**Re: Twilight Homes at Wymont Subdivision Lots 1-19, 22, and 55-58 only  
Erosion and Sediment Control Plan  
Engineer's Stamp Date 4/1/24 (G19E004\_T)**

Based on the information in your submittal received on 4/1/24, the ESC plan cannot be approved until the following comments are addressed.

# Temporary Erosion and Sediment Control Plan

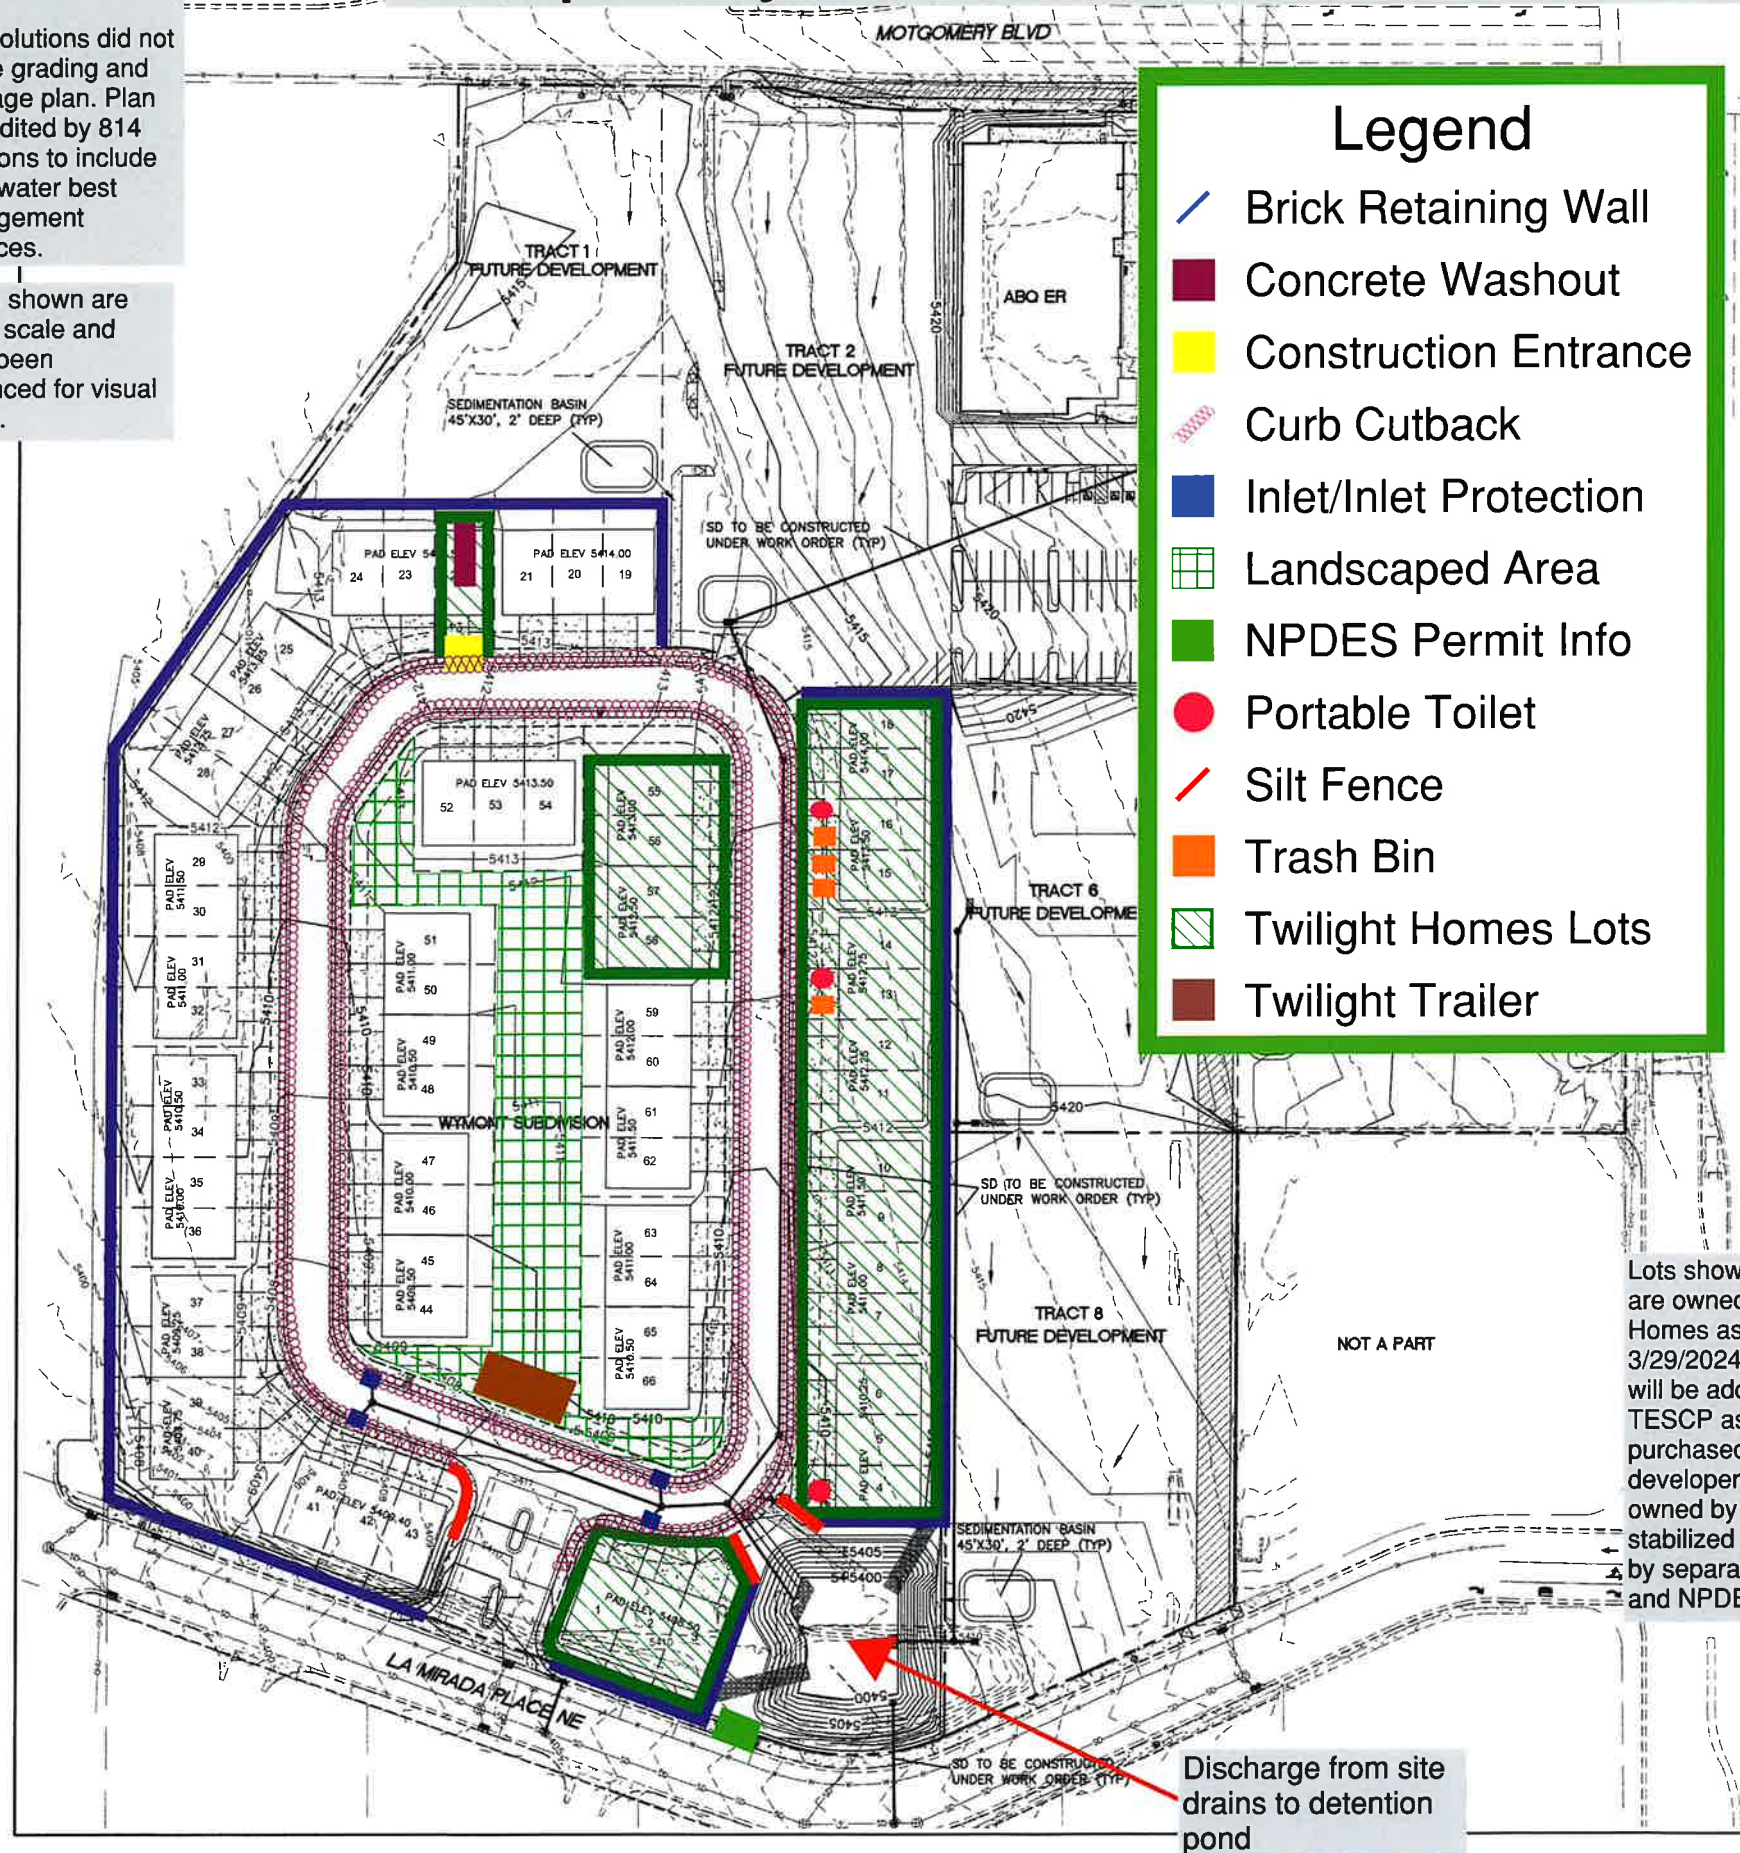
1. Per CGP 2.2.3, Cutback Swales or some other perimeter control must be shown on the ESC Plan along the frontage of Twilight Homes' lots. If cutback swales are the selected perimeter control, the design, construction, inspection, and maintenance specifications are required on the detail sheet per CGP 9.6.1.c.i.
2. Update the engineer's stamp date each time the plan changes.
